**DRAFT
Addendum #5**

**The Parkside Neighborhood Center
and Affordable Housing
Mellen & Grant Streets,
Portland, Maine 04101**

May 3, 2004

The purpose of this ADDENDUM is to respond to questions, provide coordination and clarification to the previous drawings and specifications.

BUILDING B  
A2.2

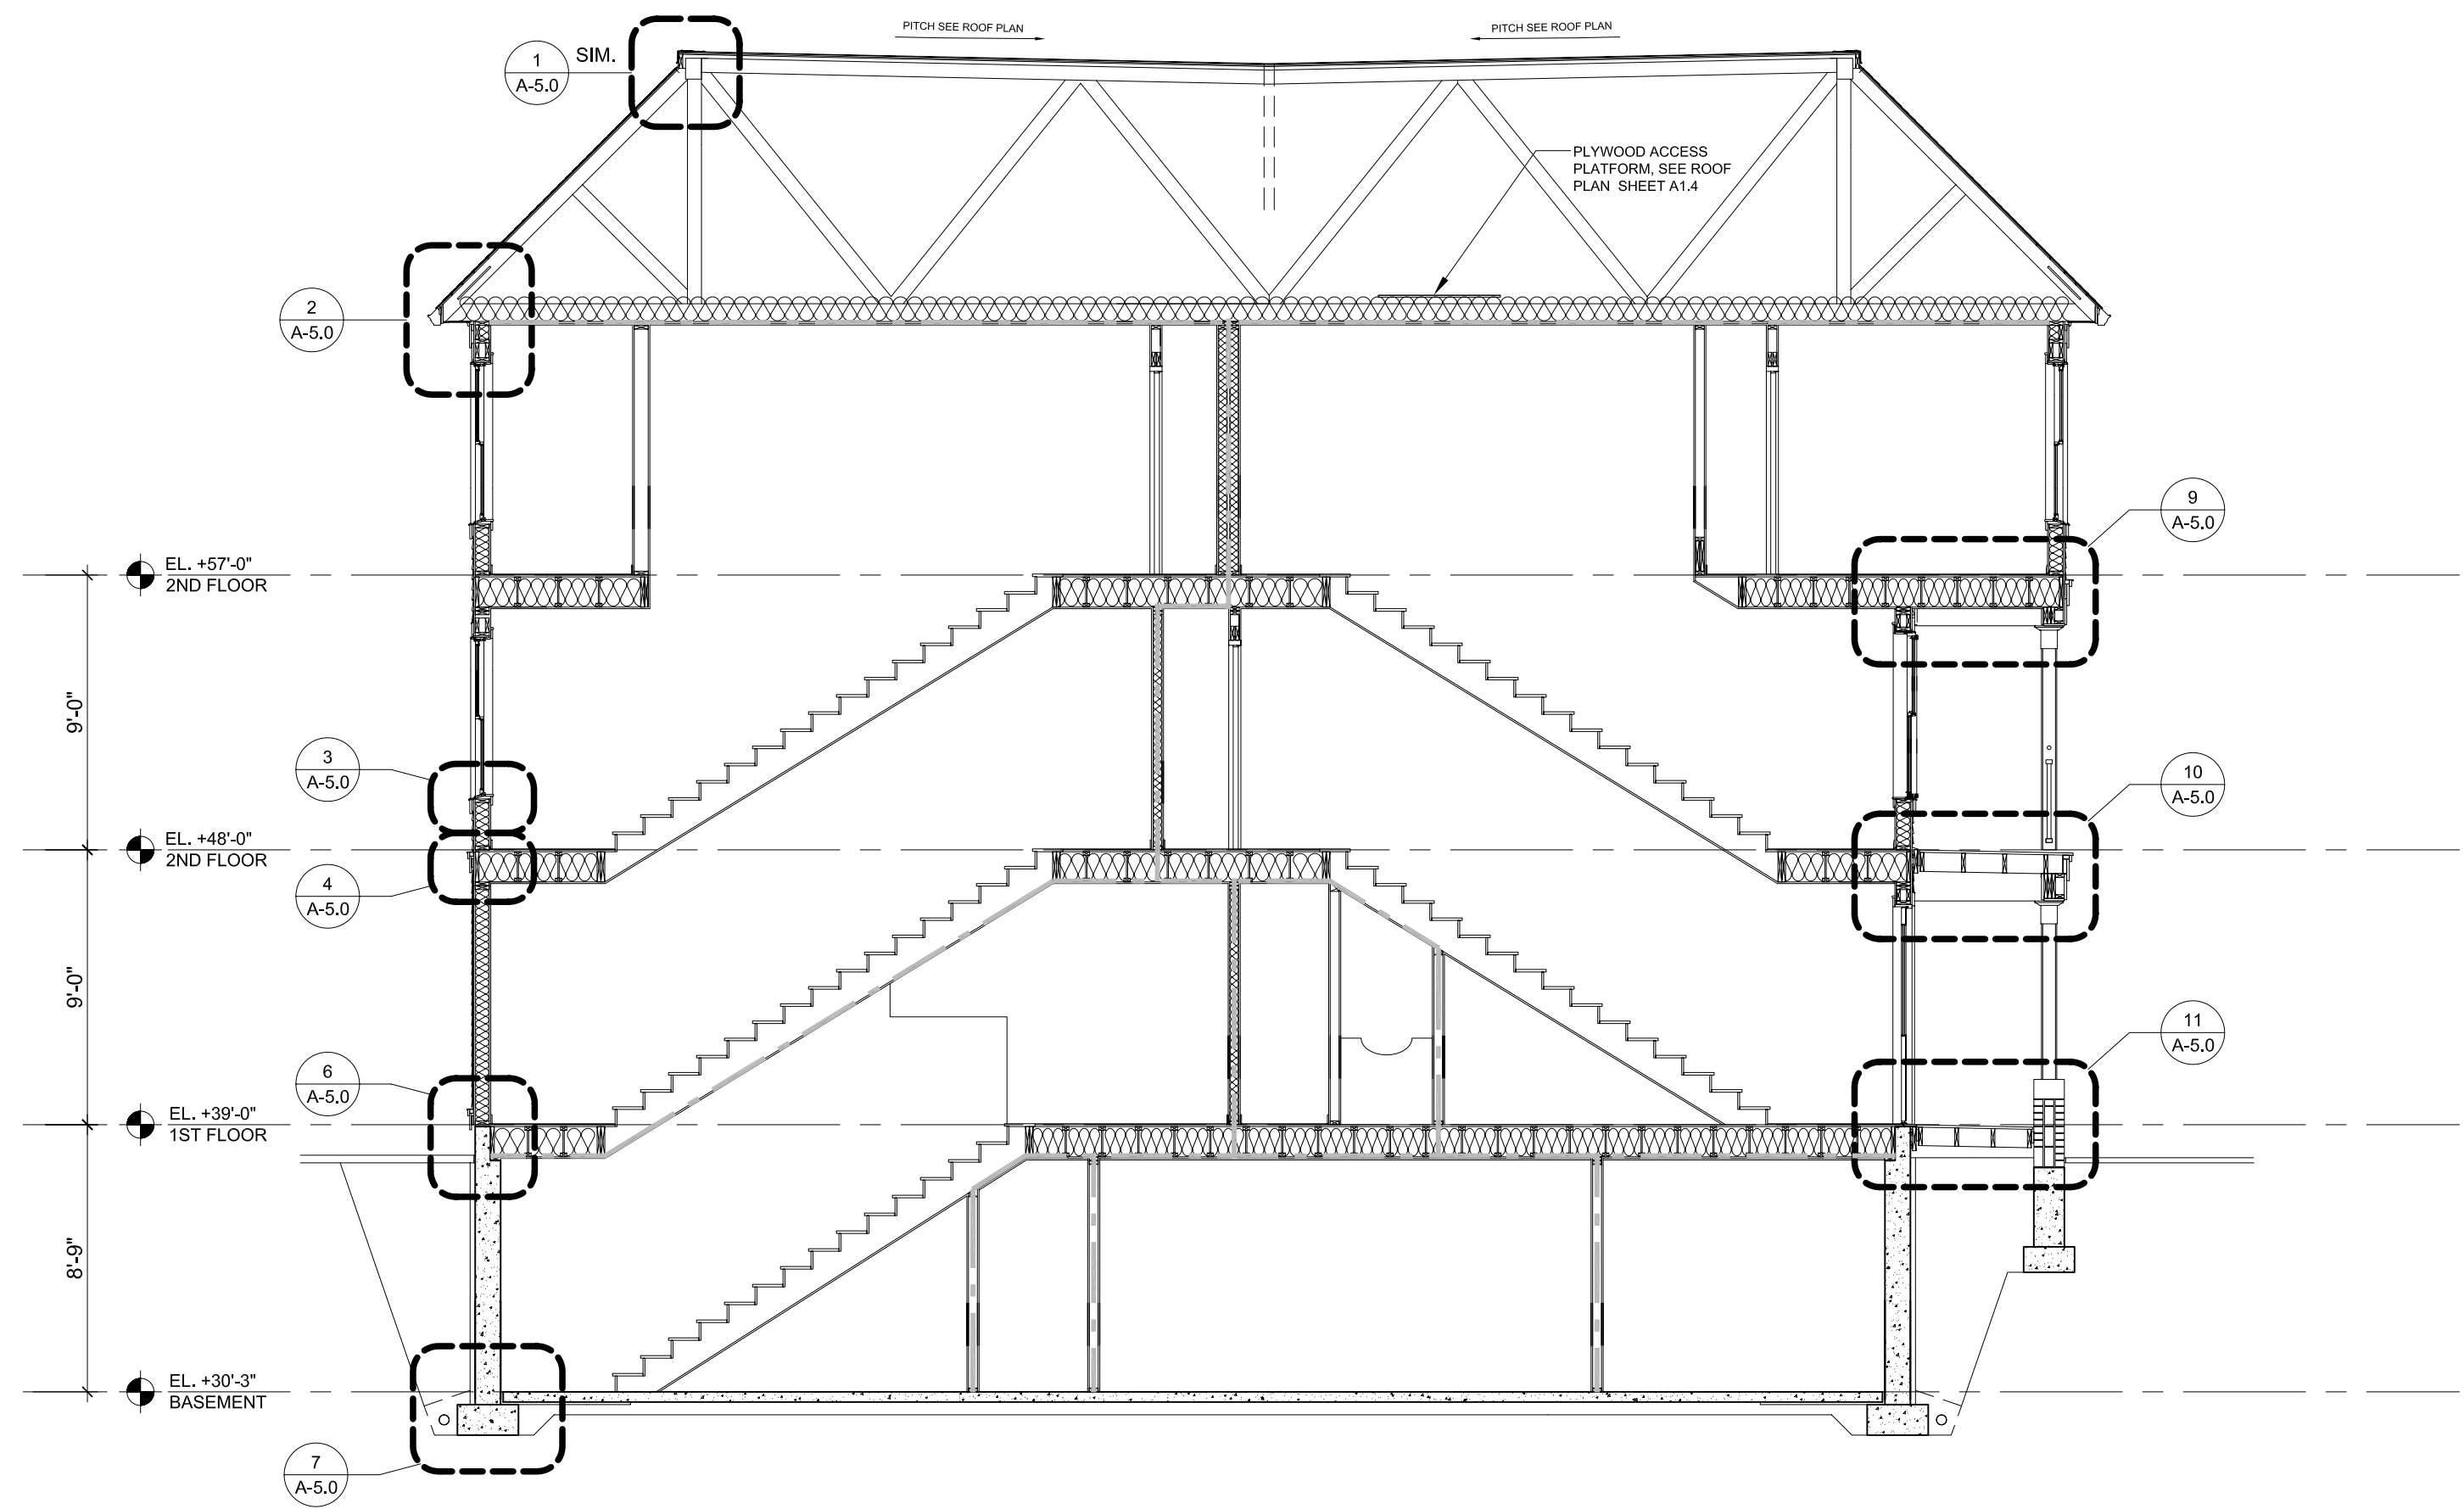
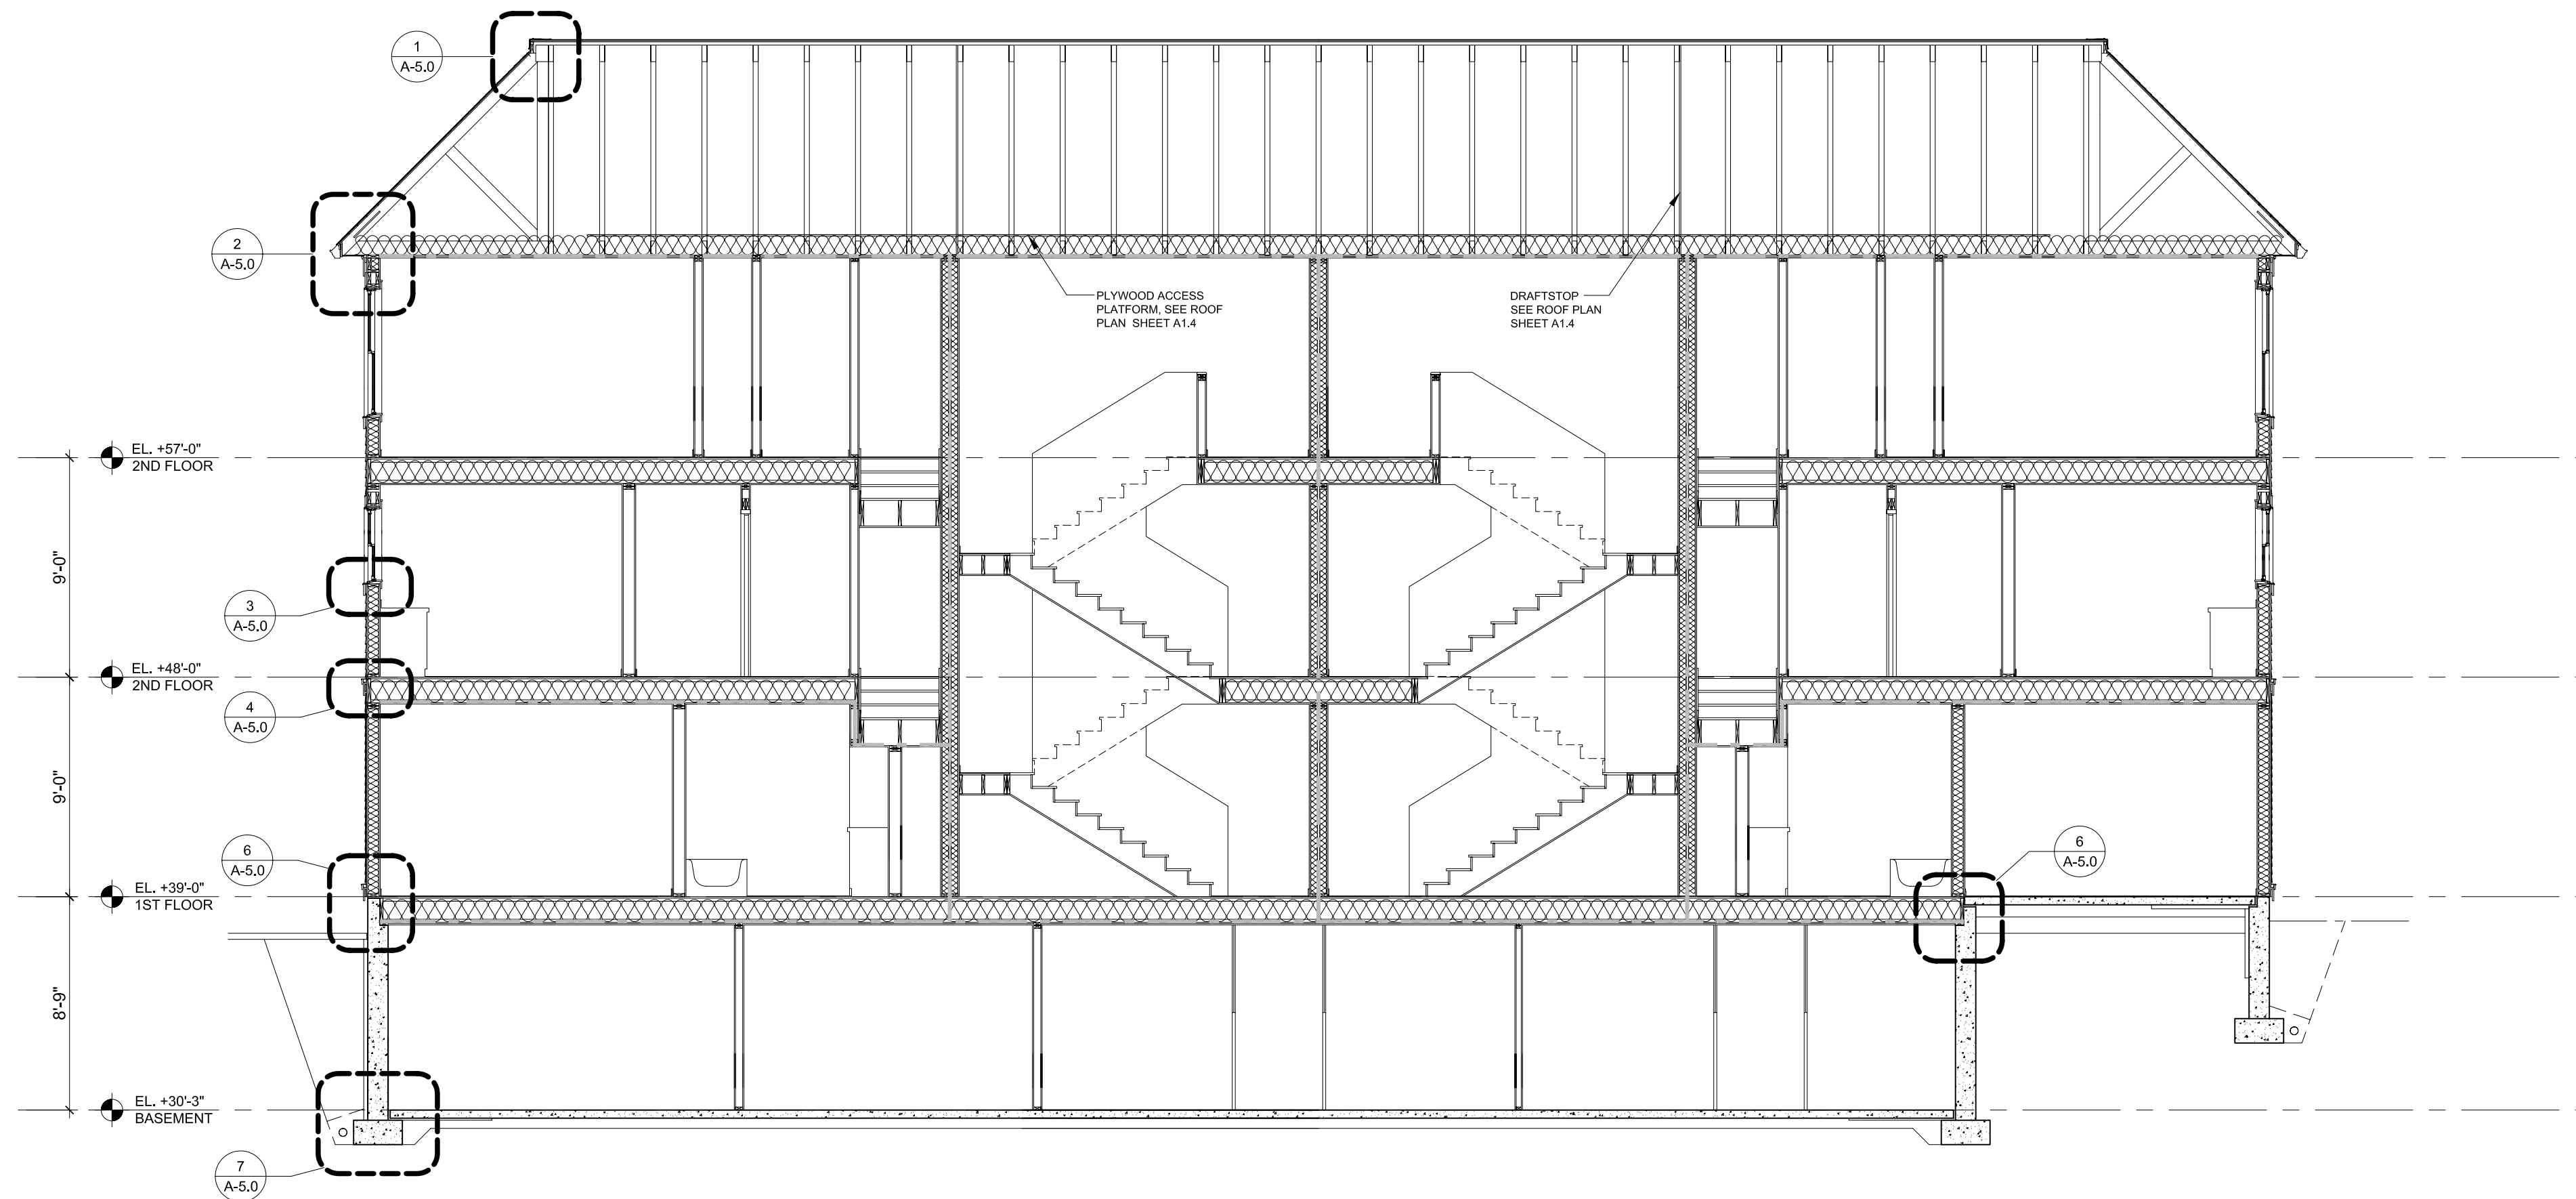
4-58	B-A2.0	2	REVISE window layout.
4-59	B-A2.2	2	Fire assemblies indicated, rating lines increased in visibility.
4-60	B-A7.0	Fin Sched.	.
